RE: SUB19-002/SEP19-005 – Proposed Preliminary Plat  
2825 W. Mercer Way, APN 2174502425  
Request for Additional Information, Third Review

The City of Mercer Island Community Planning & Development Department has completed a third review of the application materials associated with SUB19-002/SEP19-005 for compliance with the Mercer Island City Code (MICC) for the above preliminary long subdivision application. All comments must be addressed prior to issuing the staff report and scheduling the public hearing.

PRELIMINARY ROAD PLAN & SECTIONS
2825 W MERCER WAY
PRELIMINARY PLAN
 PARCEL #2174502425
 CITY OF MERCER ISLAND WASHINGTON

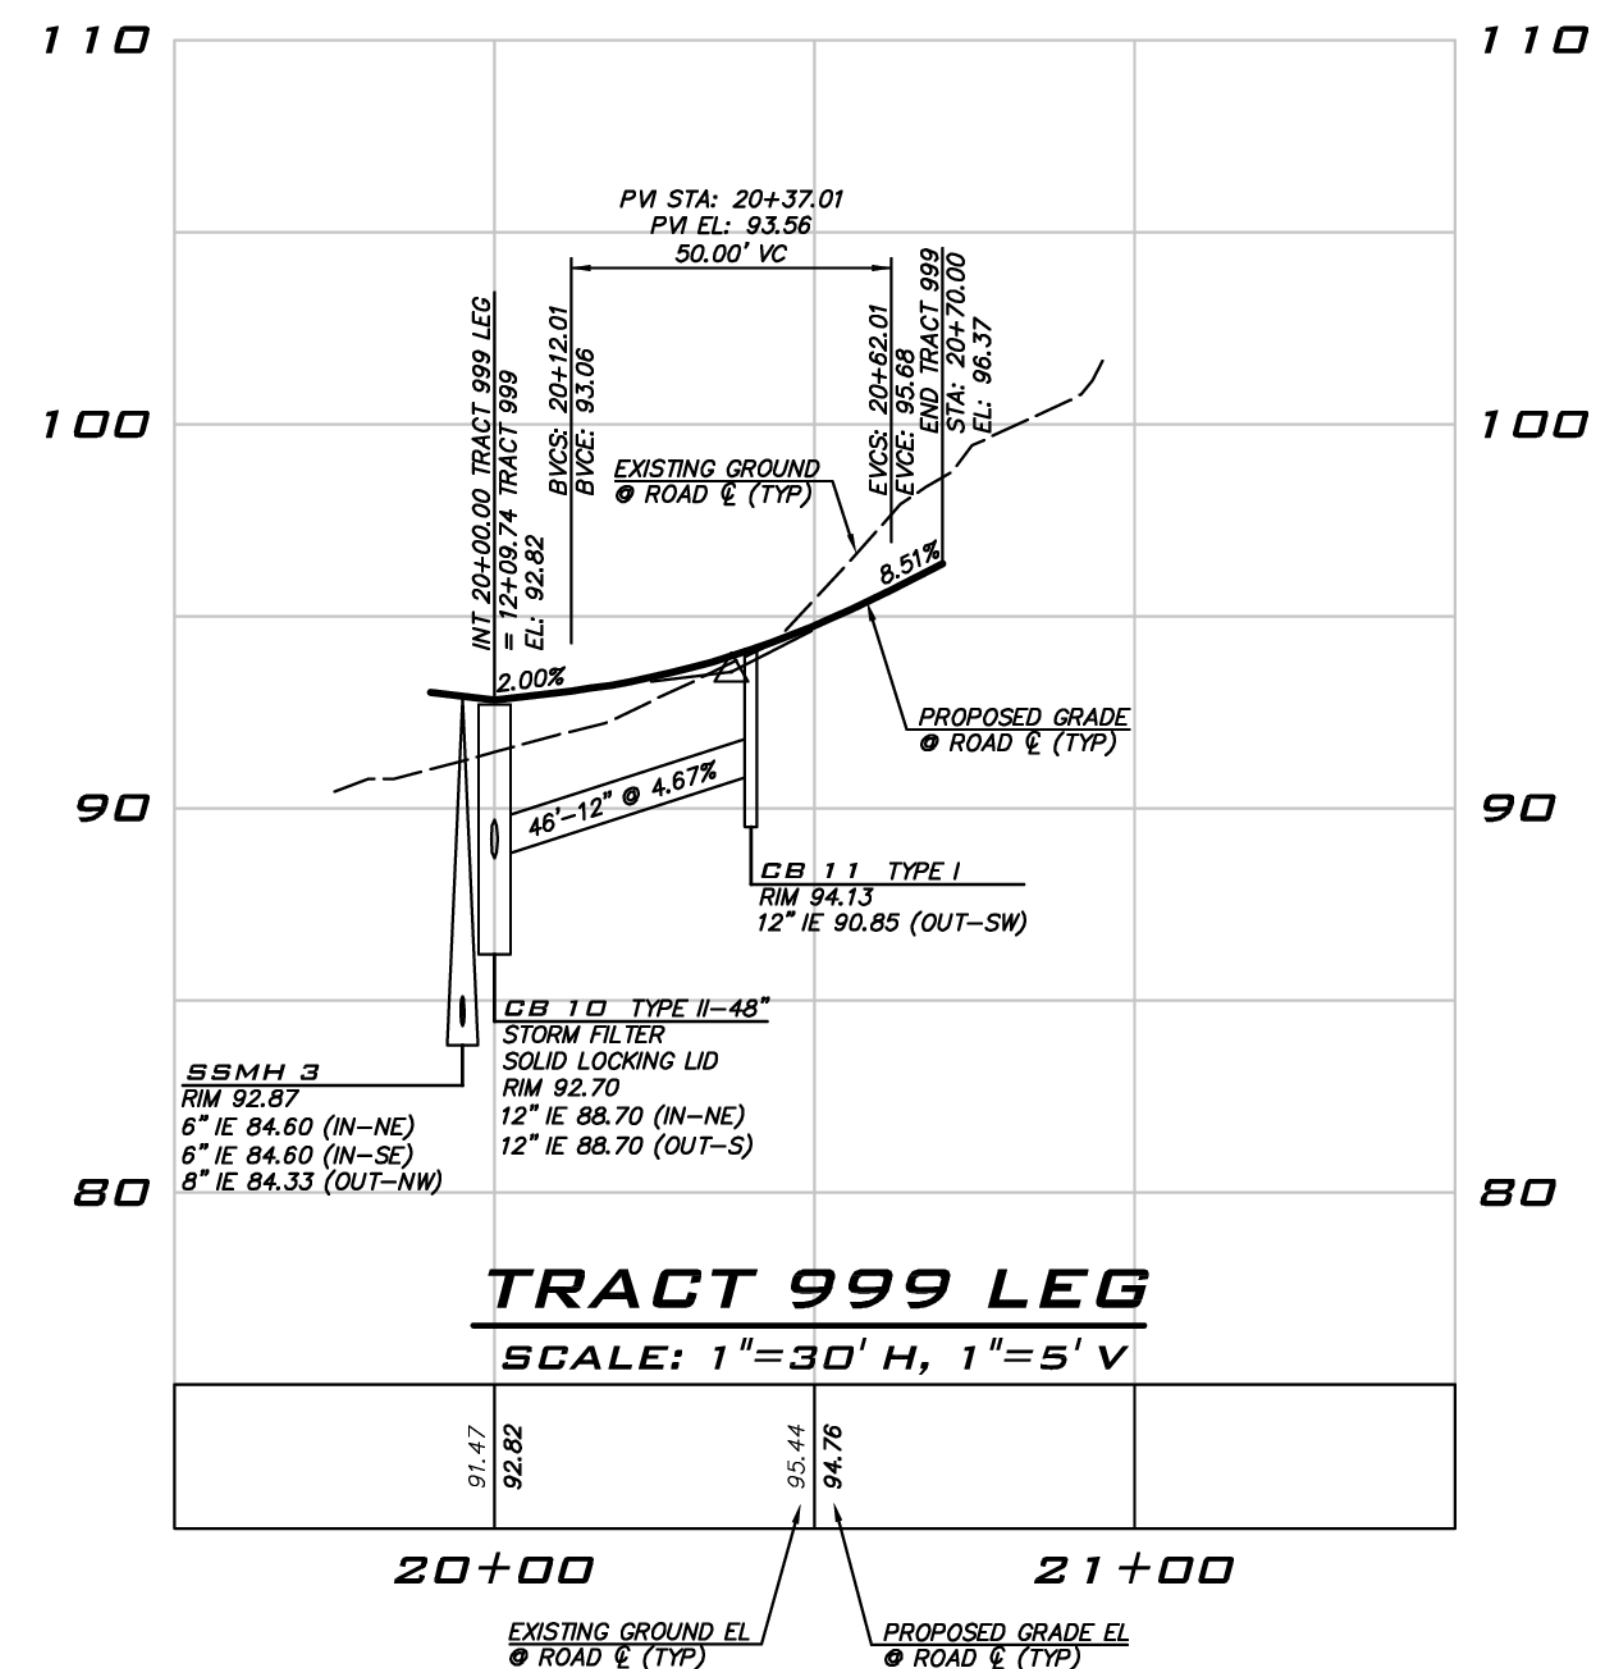
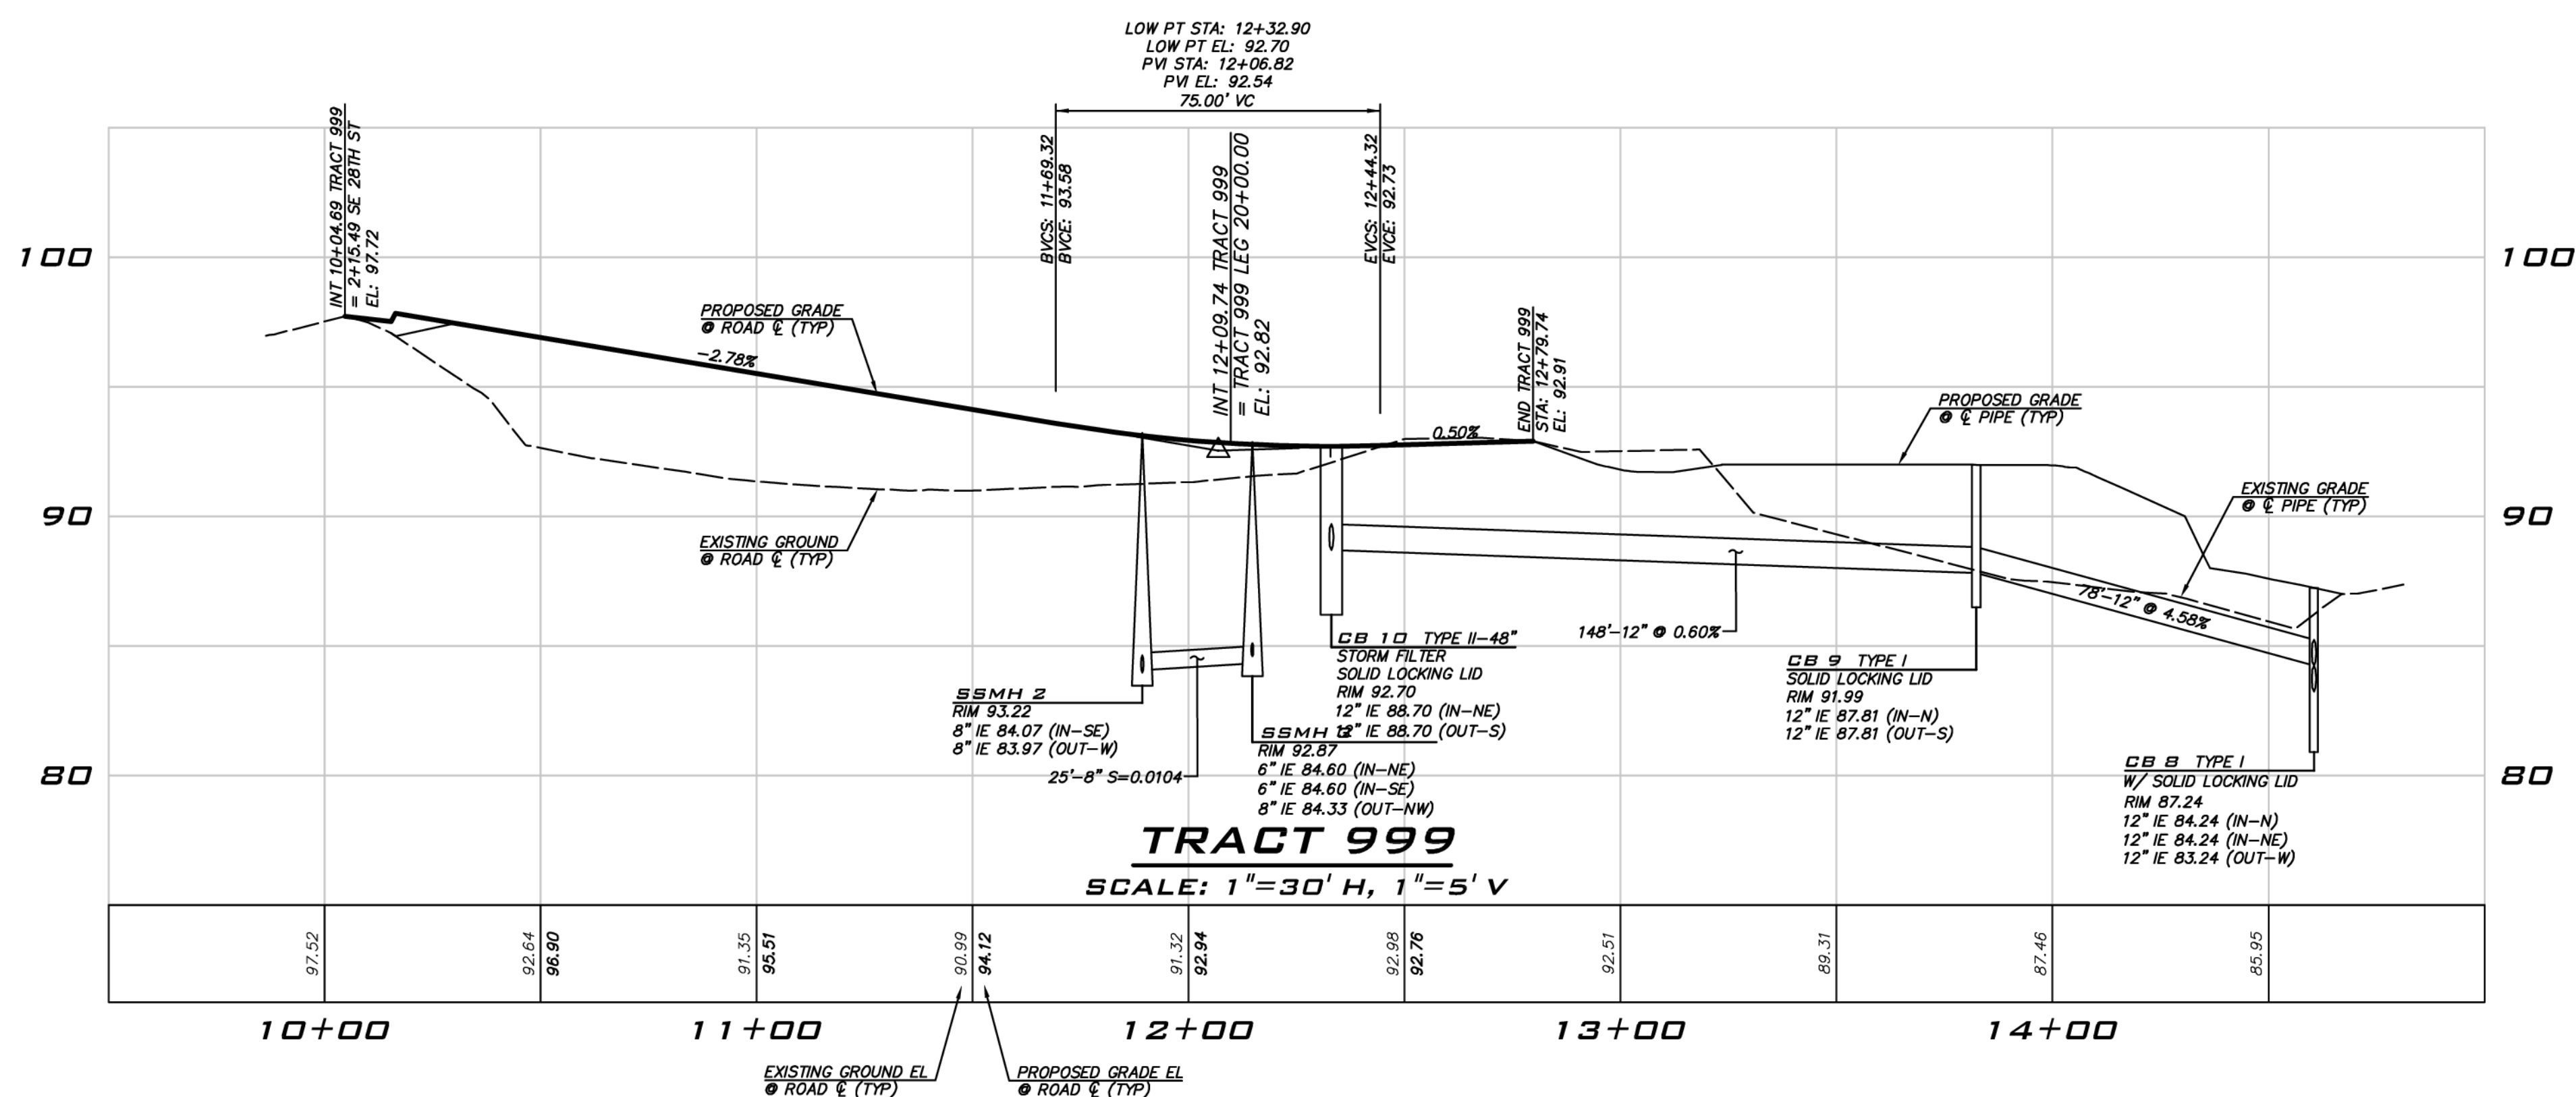
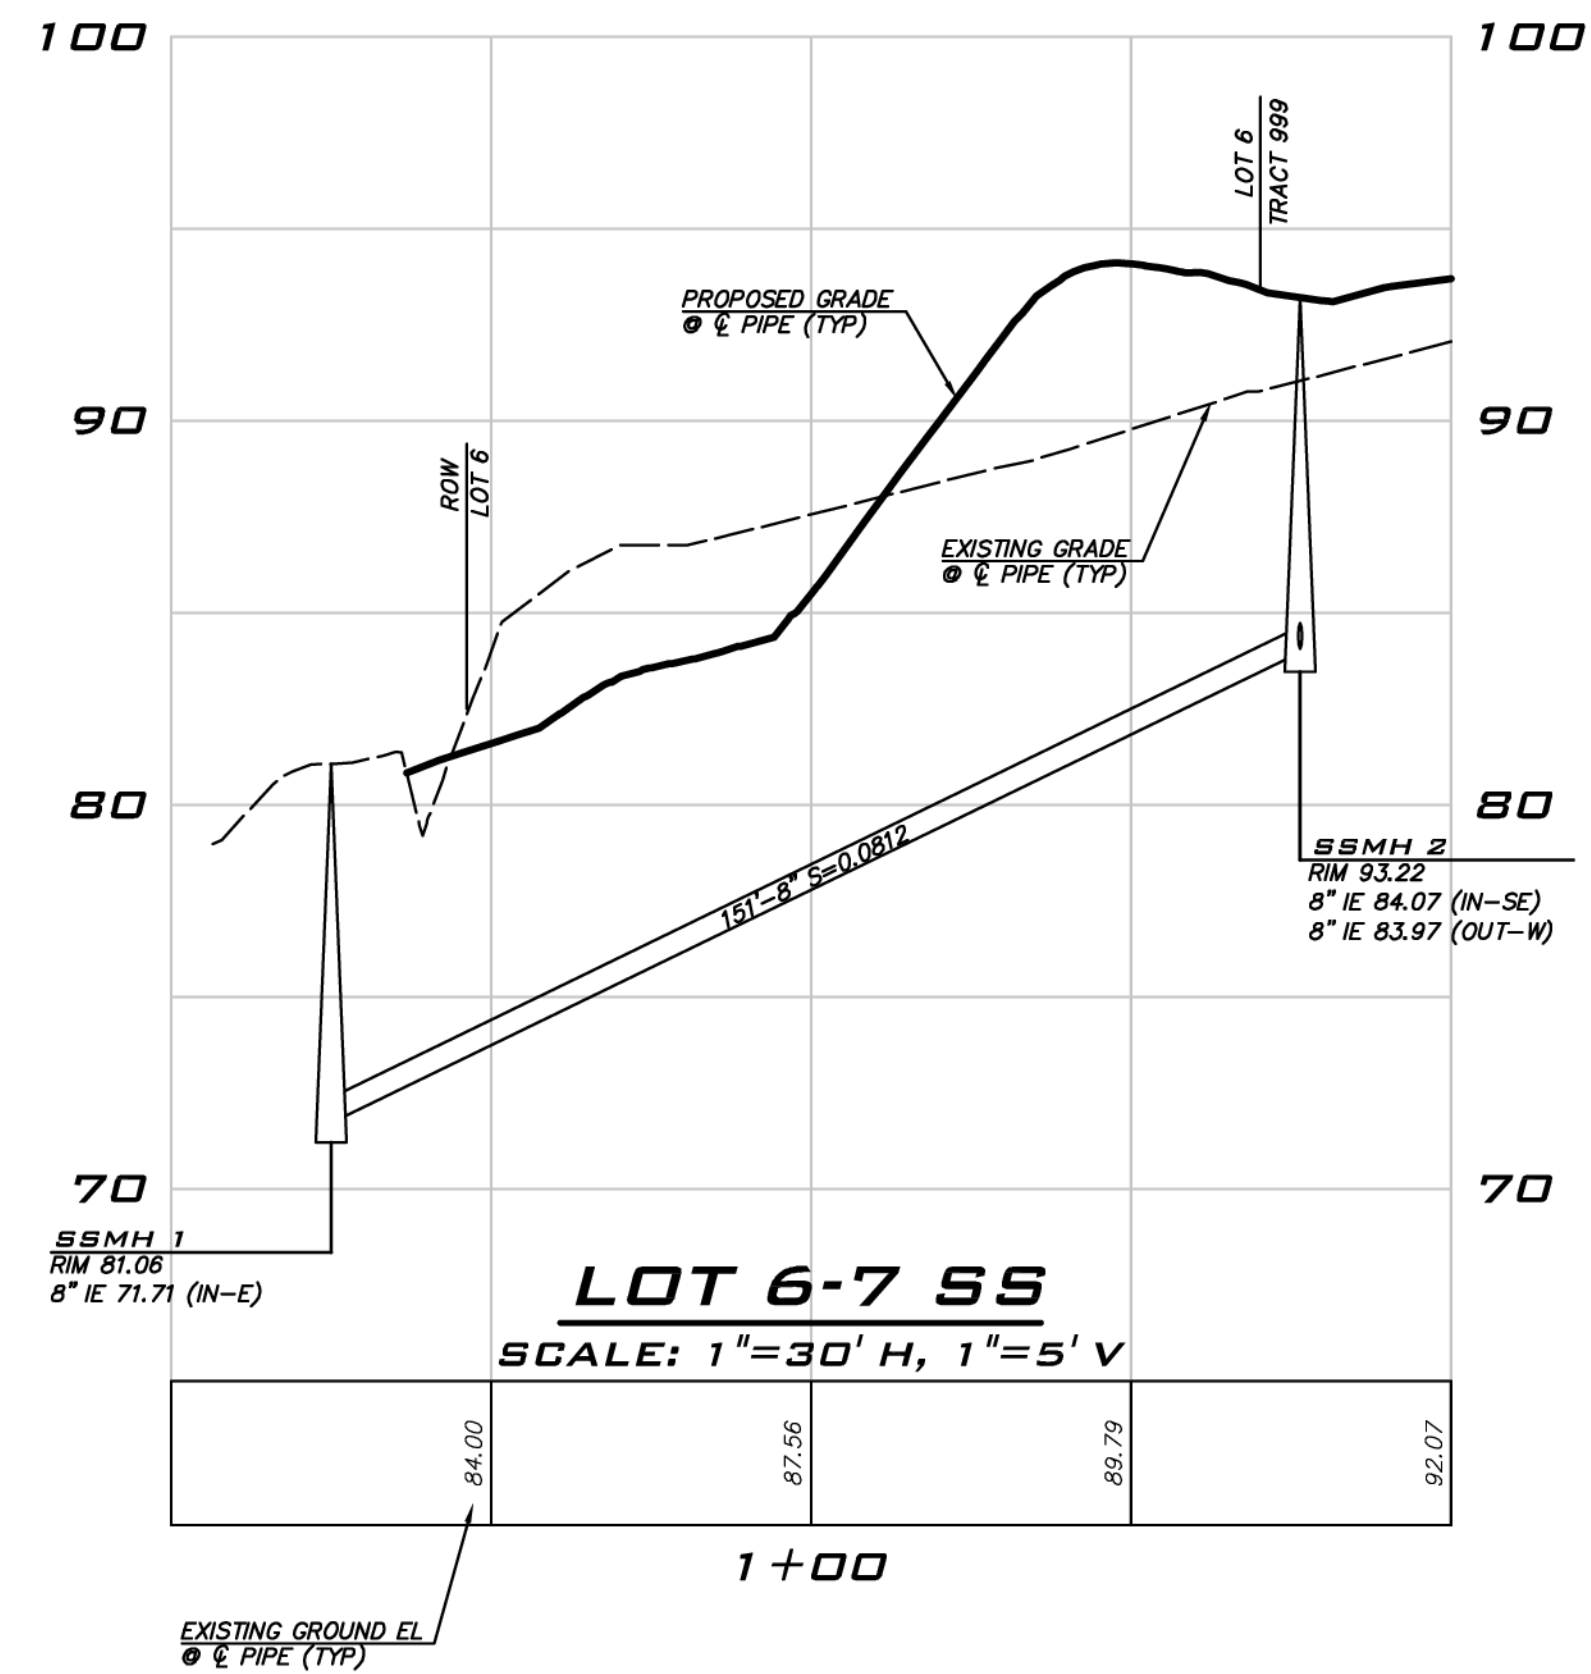
Applicant must identify turn around area on plat map and provide a plan on how this area will be maintained for fire access only and not parked vehicles. Examples would be painted lines (maintenance agreement) and/o signage.
